PLANNING WORKSHEET 11 – DELEGATED / PCG REPORT - GENERAL

Application Ref.	22/00763/HSE	
Site Address	Greenacres Linecroft Lane Walkeringham Doncaster South Yorkshire	
Proposal	Single Storey Rear Extension	
Case Officer	Daniel Galpin	
Decision Level	Delegated	
Recommendation	Grant	
Reason(s) for PCG referral		
PCG Sign off and date		
	Signature	Date
Case Officer	<i>D. Galpin</i>	12 th July 2022
Authorised signing Manager	<i>J. Through</i>	18 th July 2022

client		
<b>Mr &amp; Mrs Witney</b>		
project		
<b>Proposed Extension Walkeringham</b>		
drawing		
<b>Proposed Layout &amp; Elevations</b>		
date	scale	sheet
MAY 2022	1:50	@ A1
LR	LP

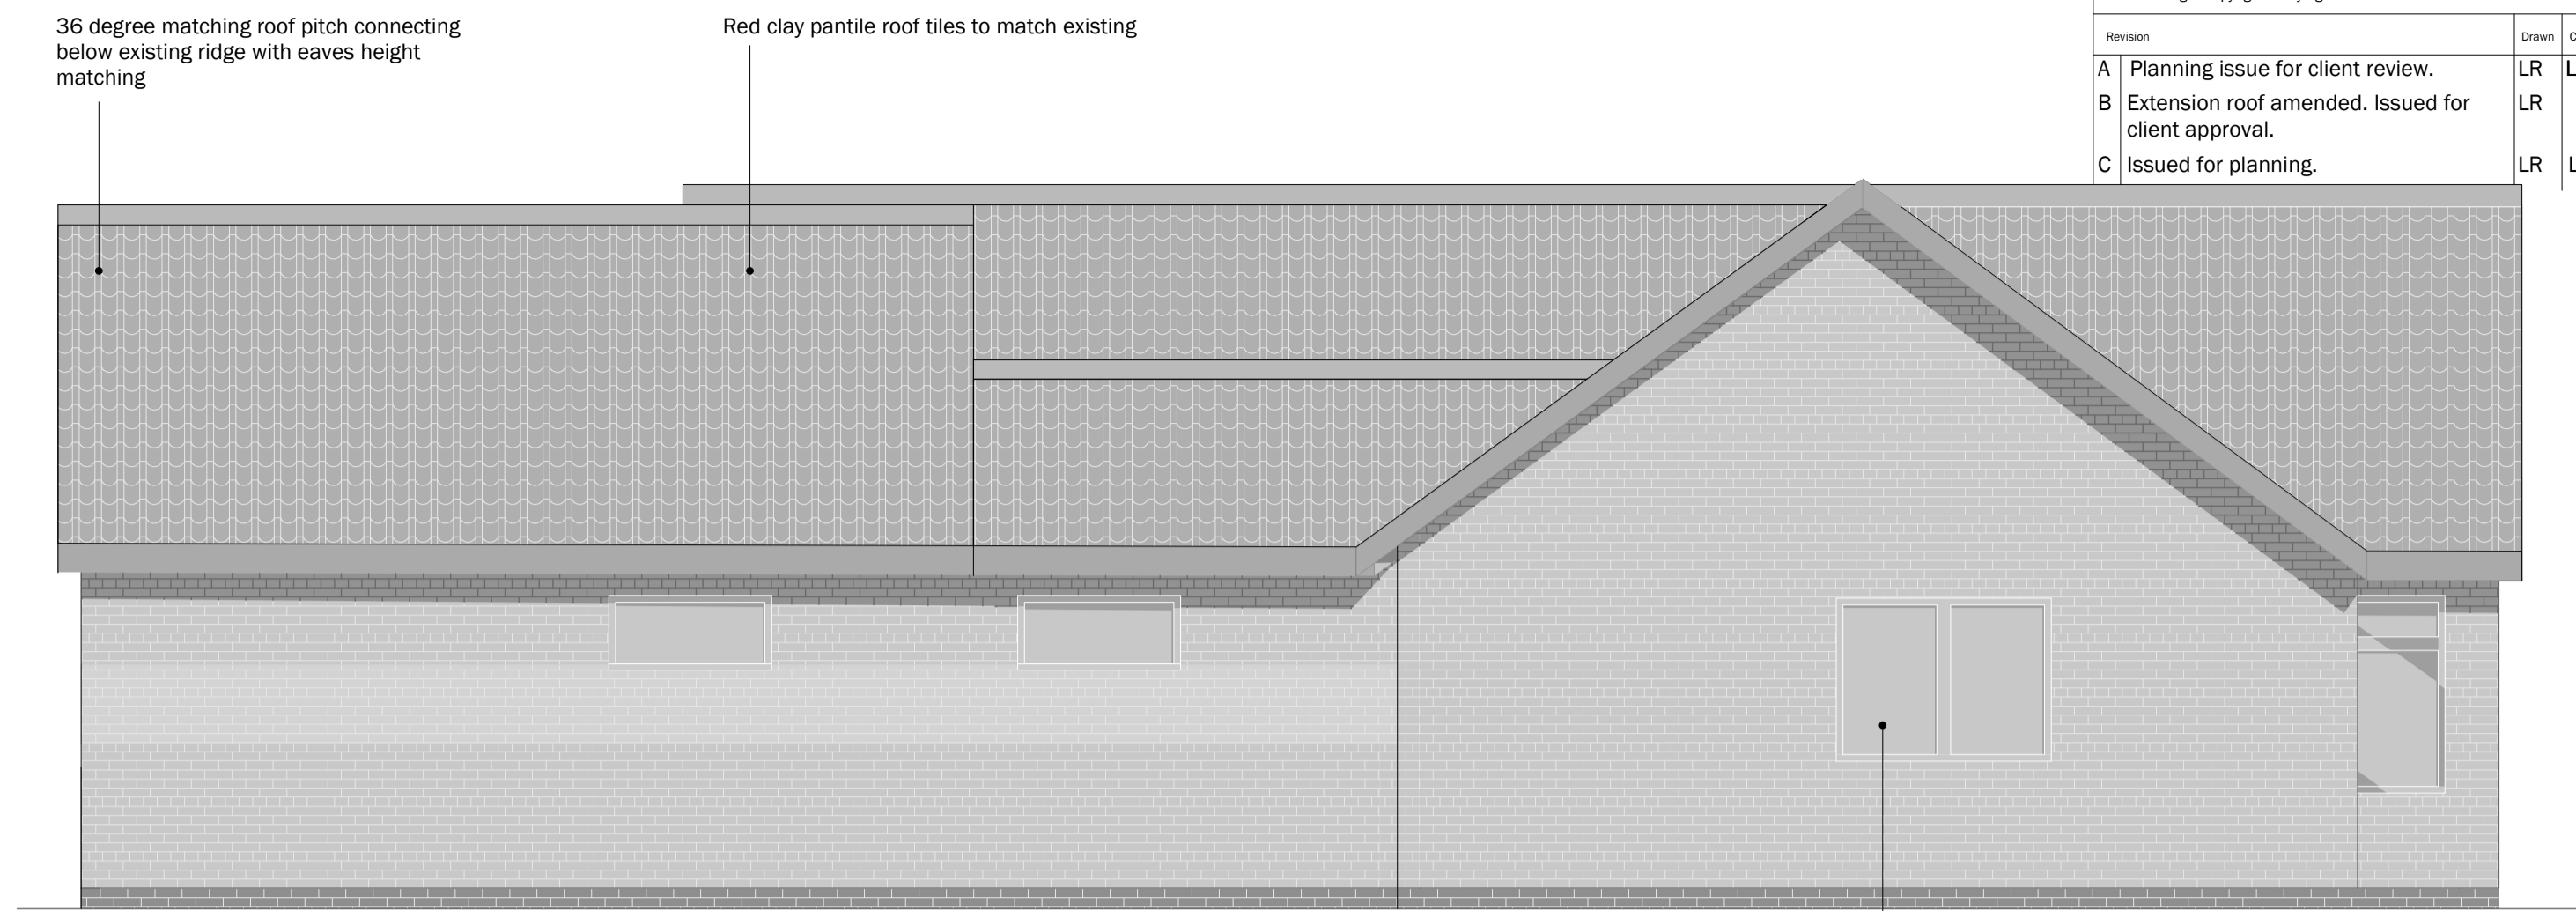
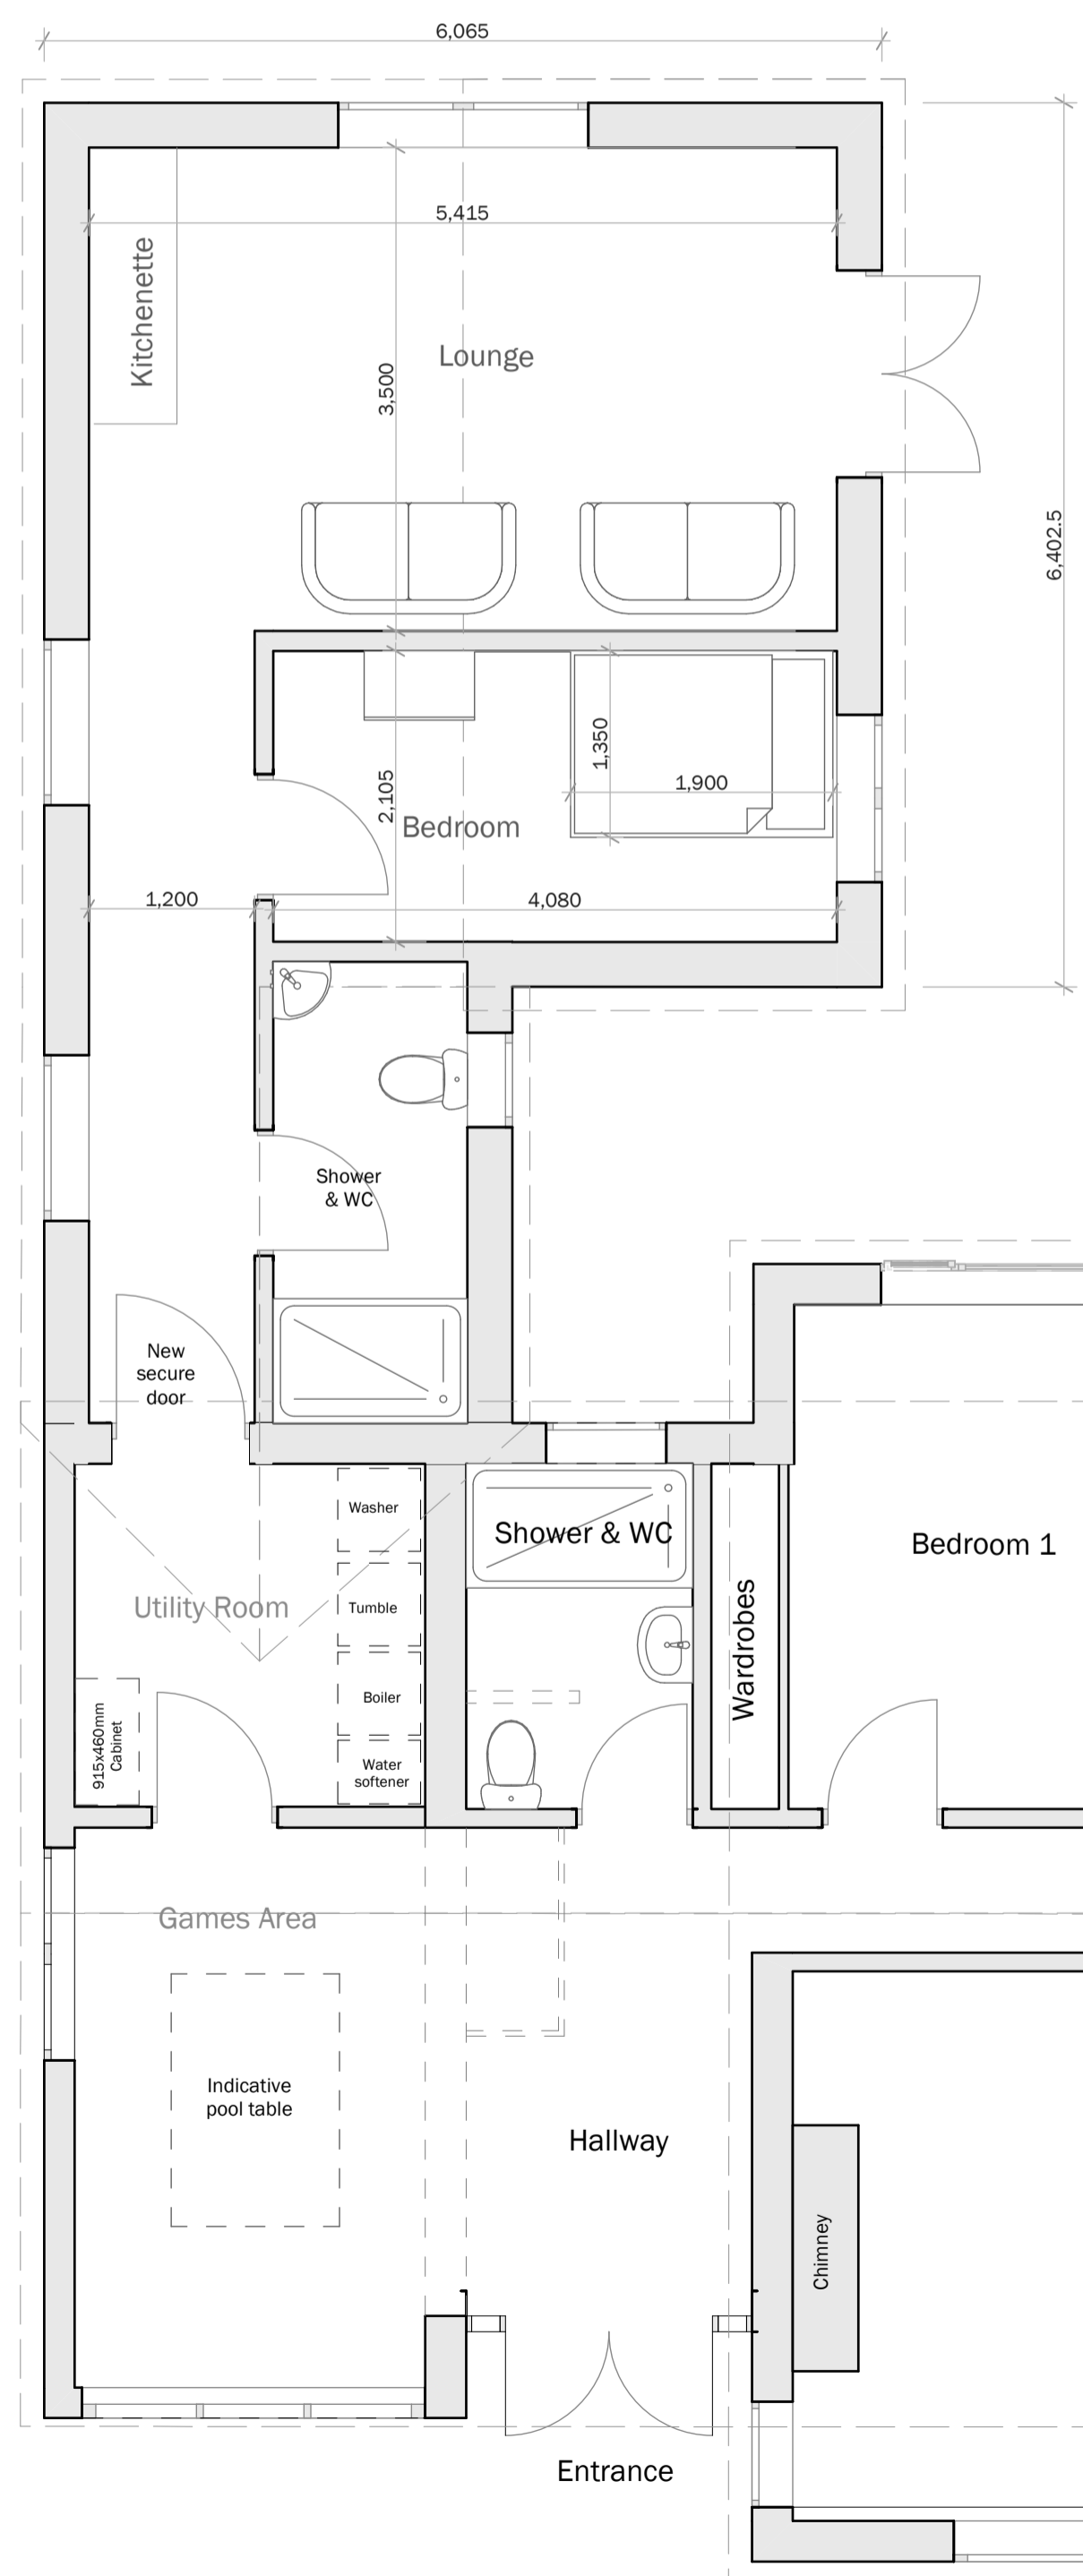
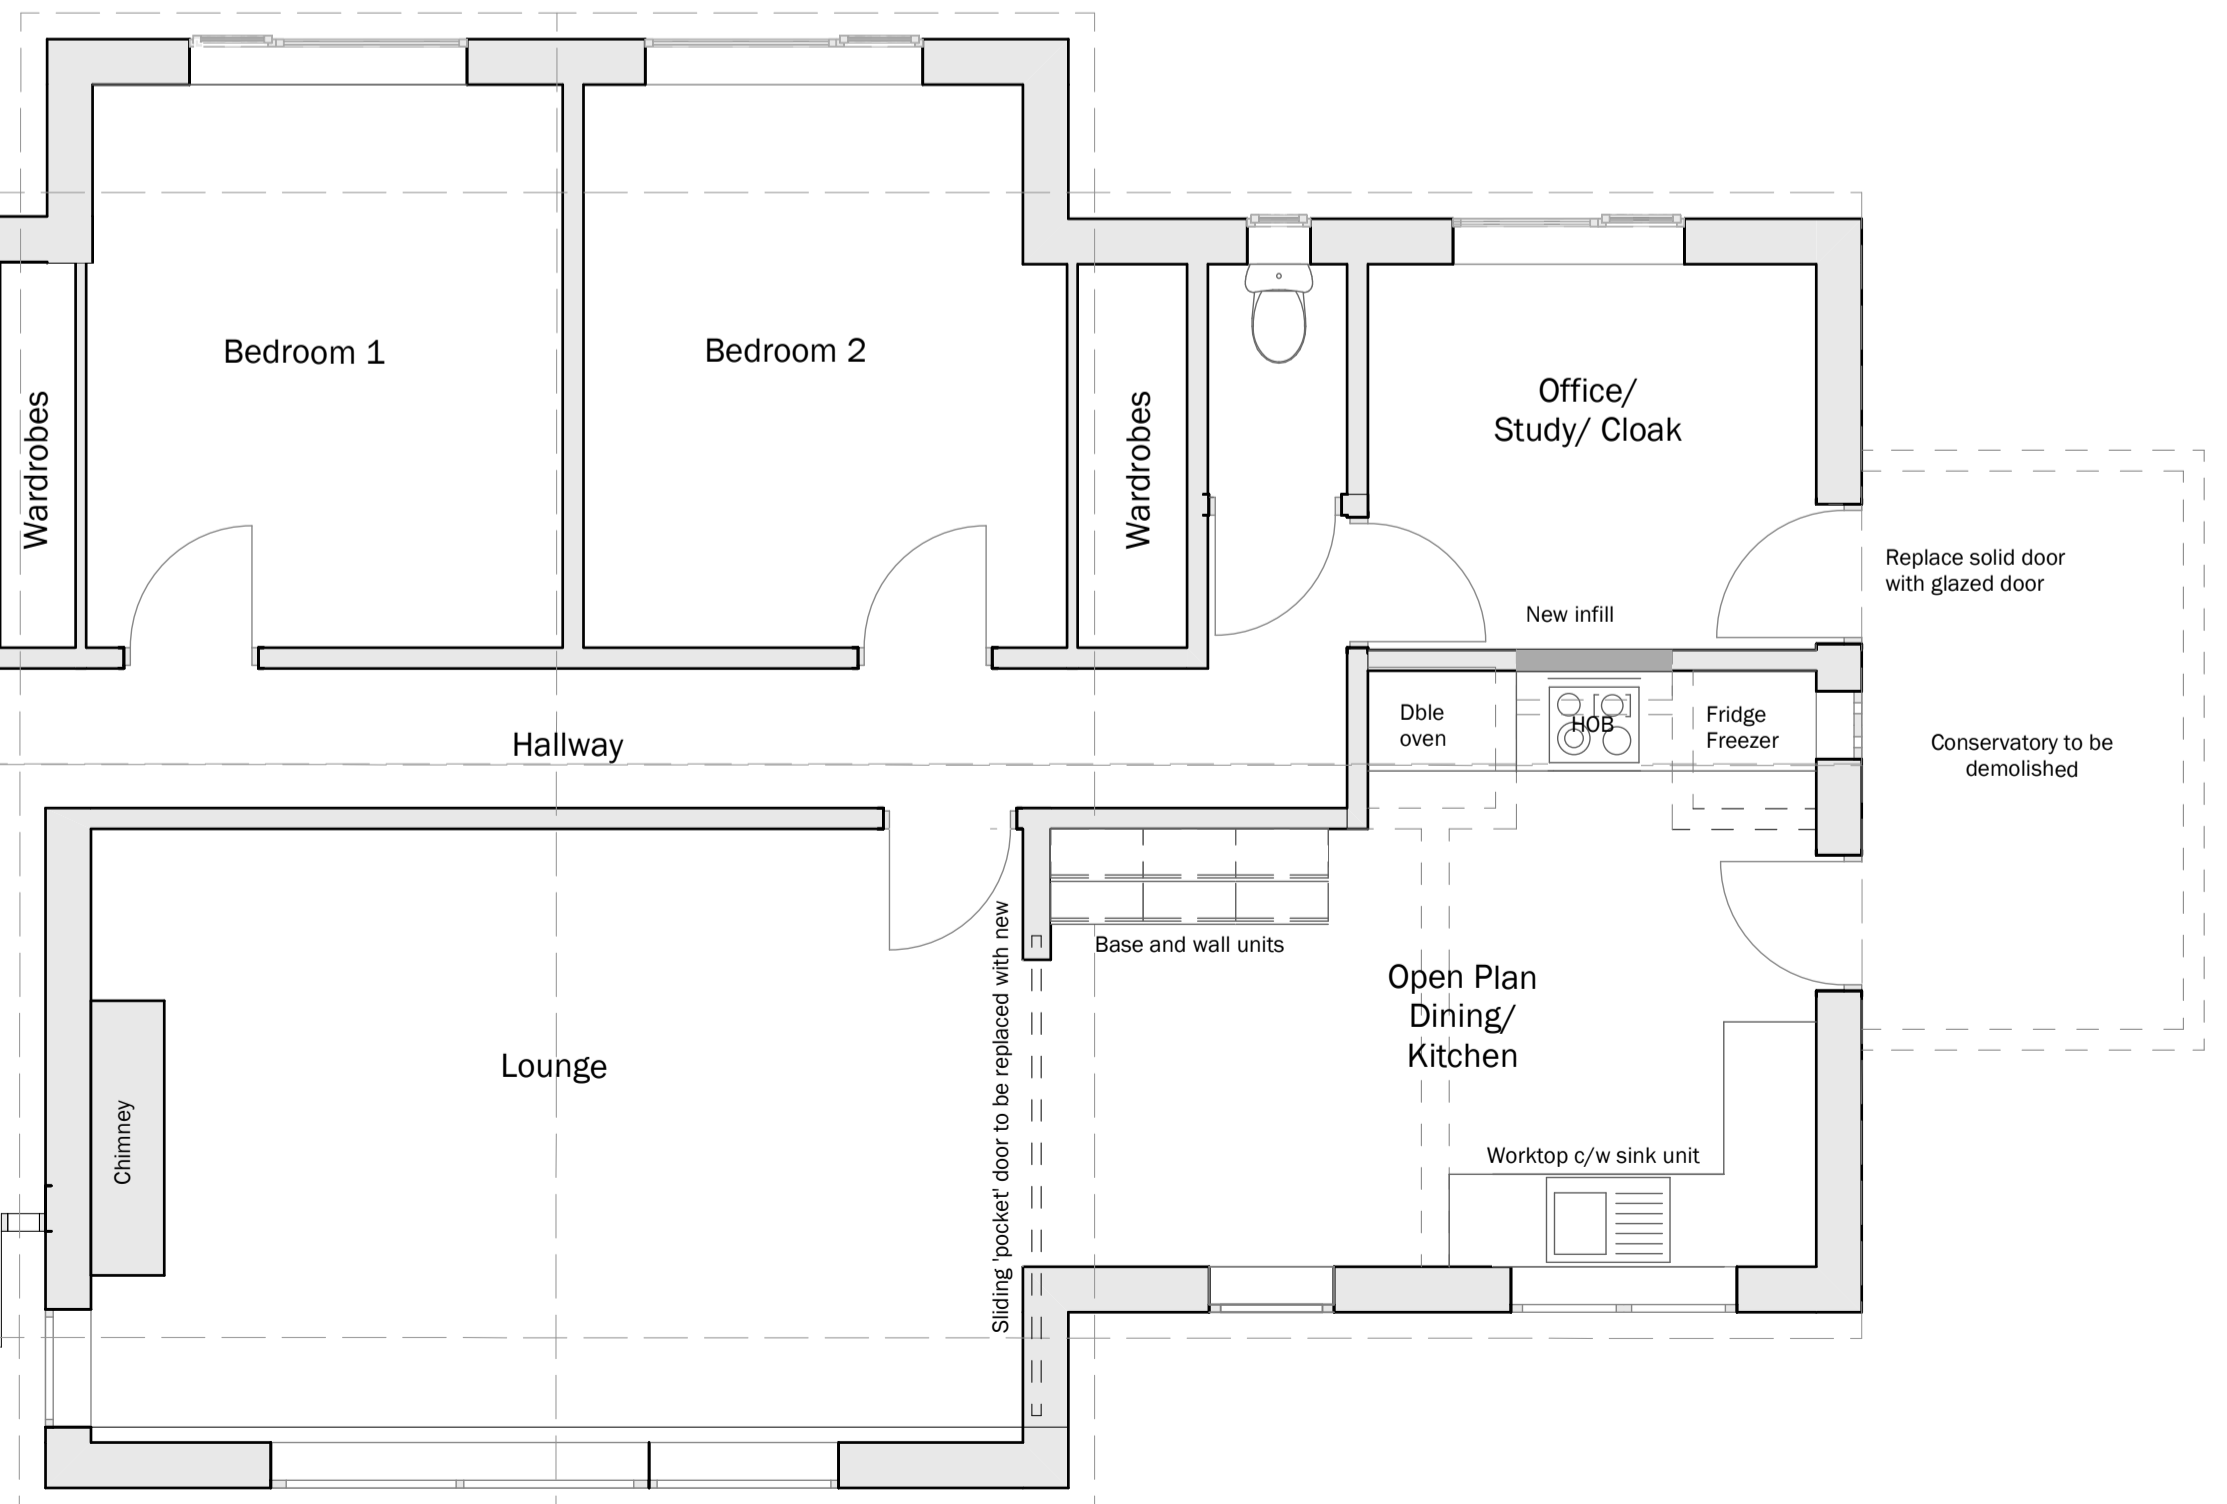
It is proposed to have a rear extension that projects approximately 8 metres from the rear elevation. Although this is at the upper end of what would be considered acceptable for a residential bungalow extension, the resulting L-shape design is considered to be acceptable and would mean the bungalow form of the dwelling is retained. The use of matching materials will also help to ensure that the character of the dwelling is retained and the proposal is sympathetic to its surroundings.

Planning permission is being sought for a single storey rear extension which will project approximately 8 metres from the rear of the rear elevation of the dwelling and will measure approximately 5 metres in height which is very slightly lower than the ridge height of the main dwelling. It is proposed that the dwelling will be constructed with buff bricks and a pantile roof to match the existing dwelling.
